**Consultation Response from KC,
Lead Local Flood Authority**

2024/92806 Land at, Penistone Road, Fenay Bridge, Huddersfield, HD8 0AW

Discharge of details reserved by conditions 20 (surface water discharge), 21 (flood routeing) and 31 (grass-crete and batter maintenance) of previous permission 2022/93154 for erection of 68 dwellings with associated access, parking, open space, landscaping and infrastructure works (including installation of surface water attenuation tank)

Date Responded: 28th October 2025

Gully Catchment Plan

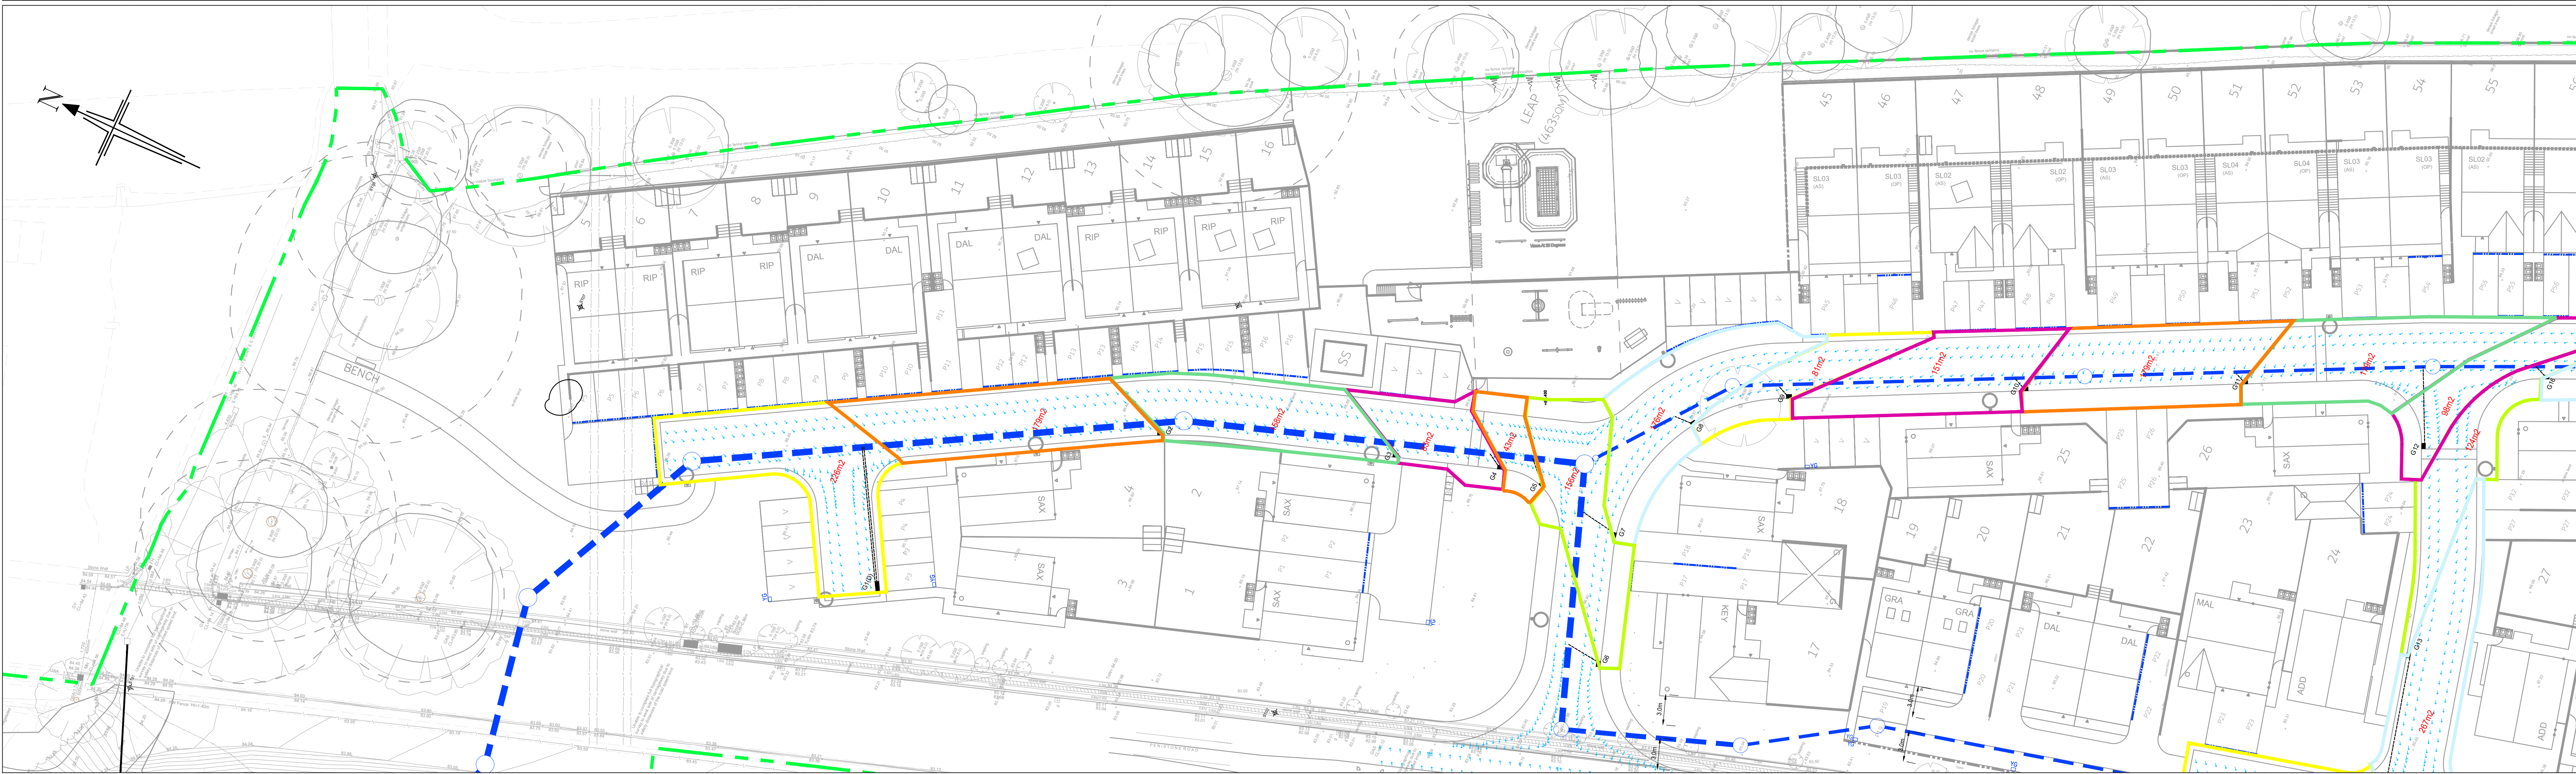
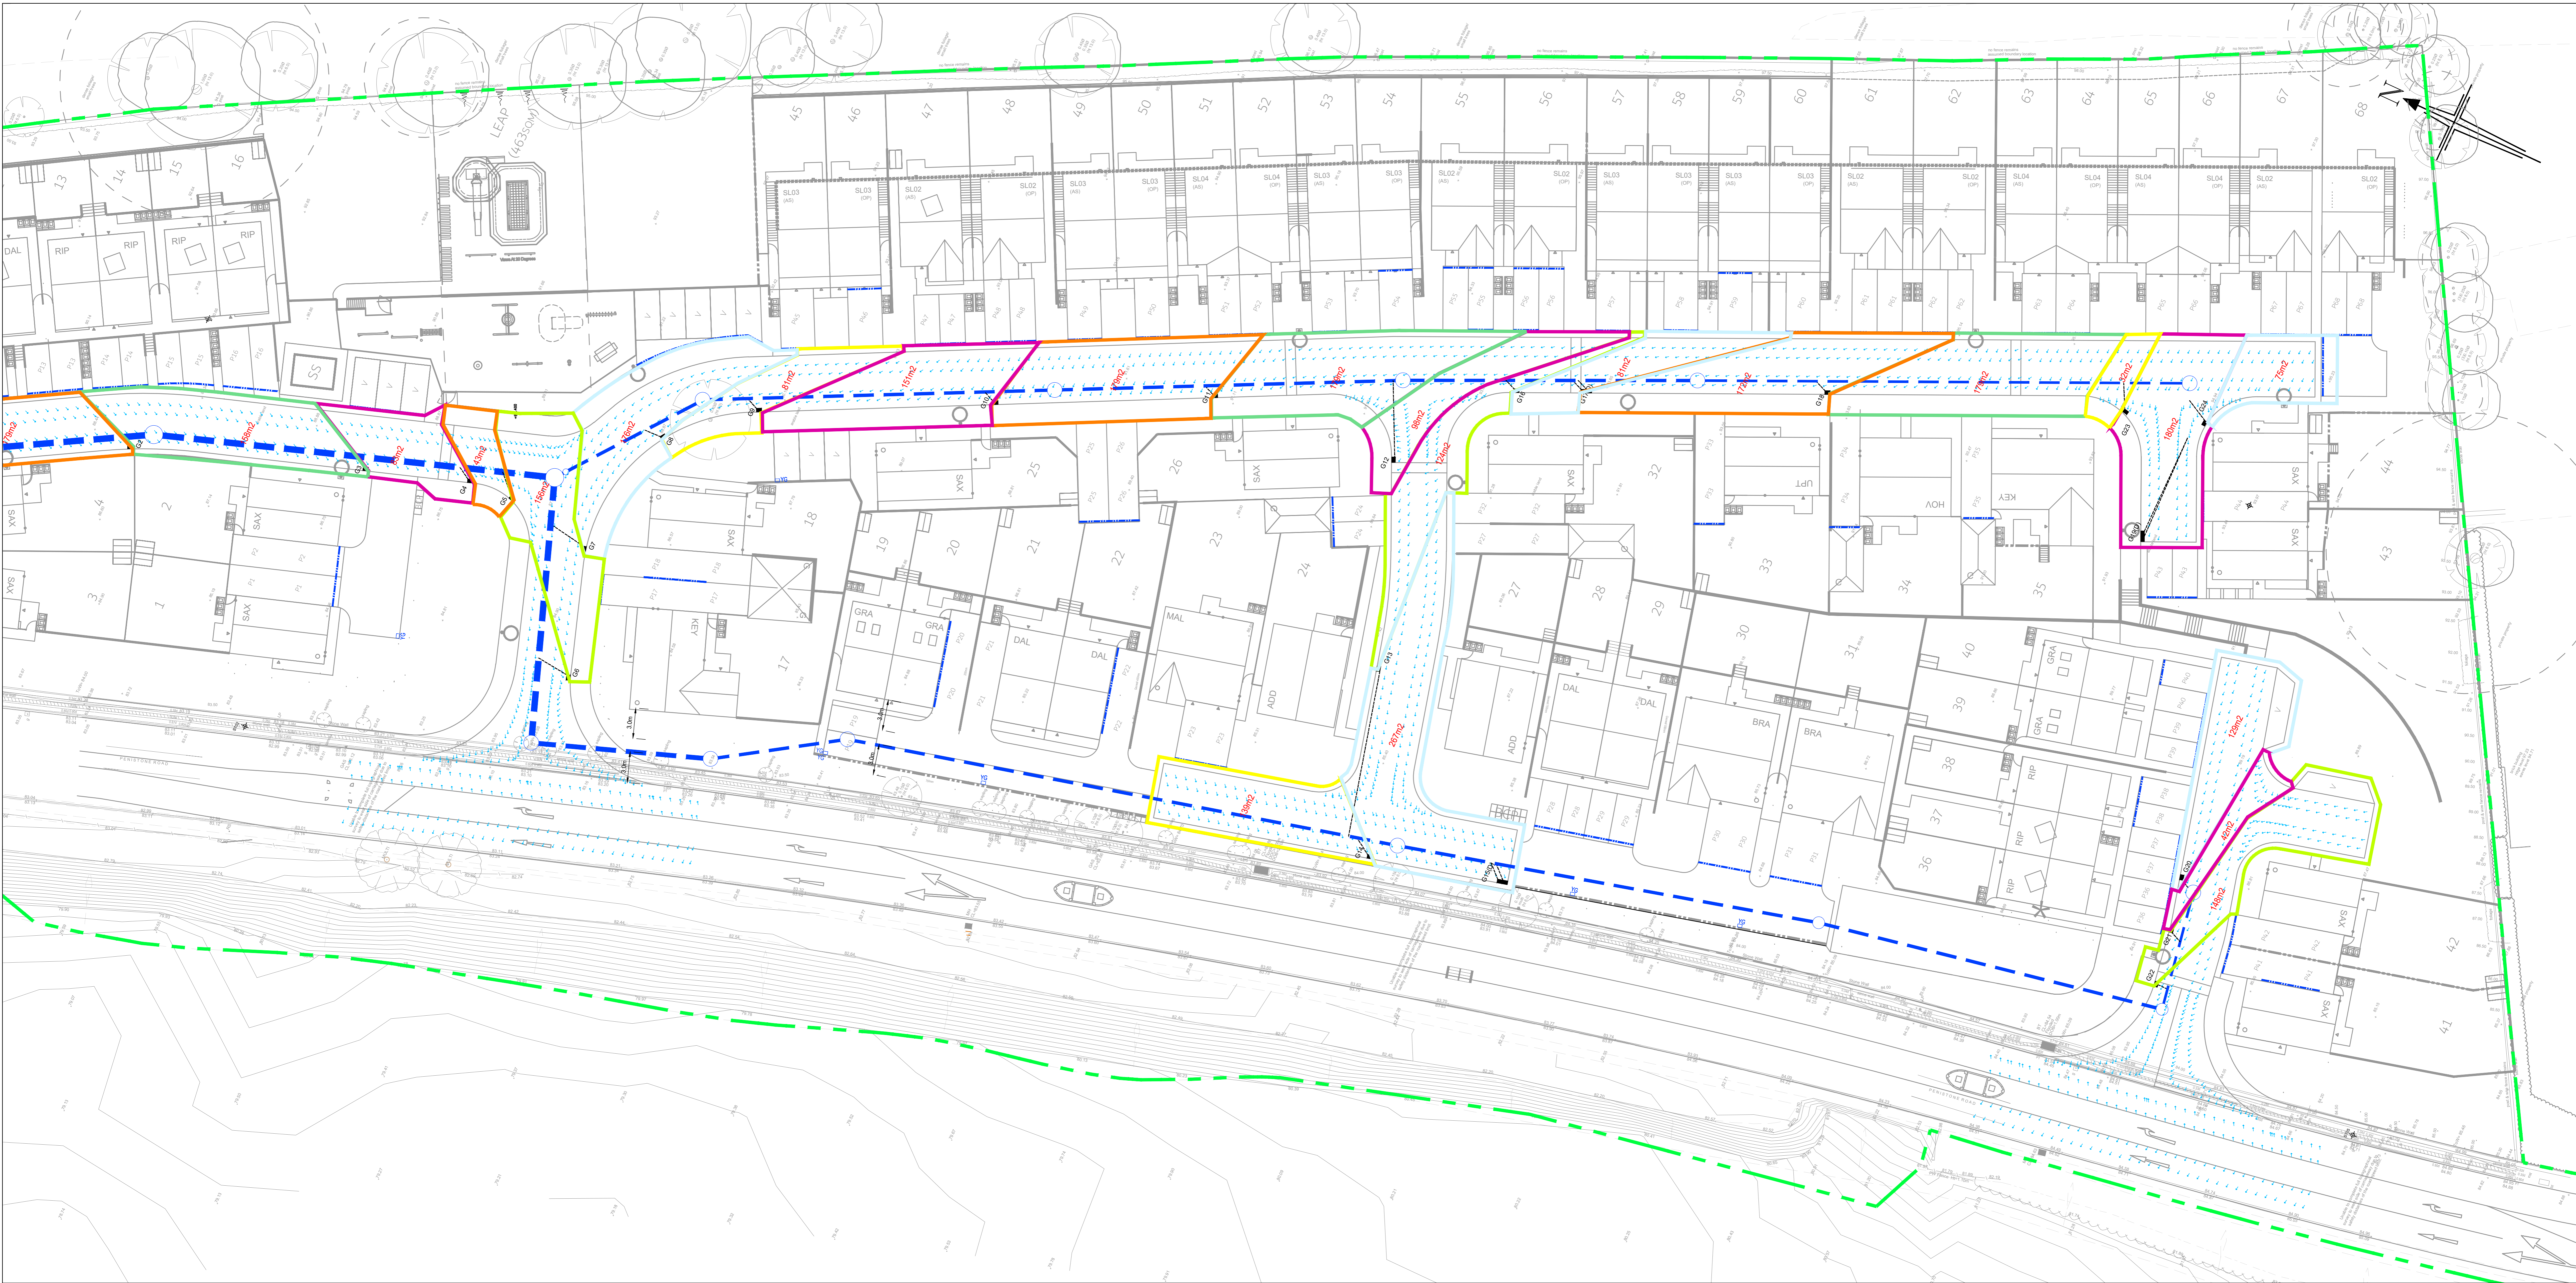
Further to our comments of 17th April 2025 and subsequent submissions for drainage. I can confirm that various discrepancies between drainage layout plans, hardstanding contributing areas and simulation modelling, have been ironed out.
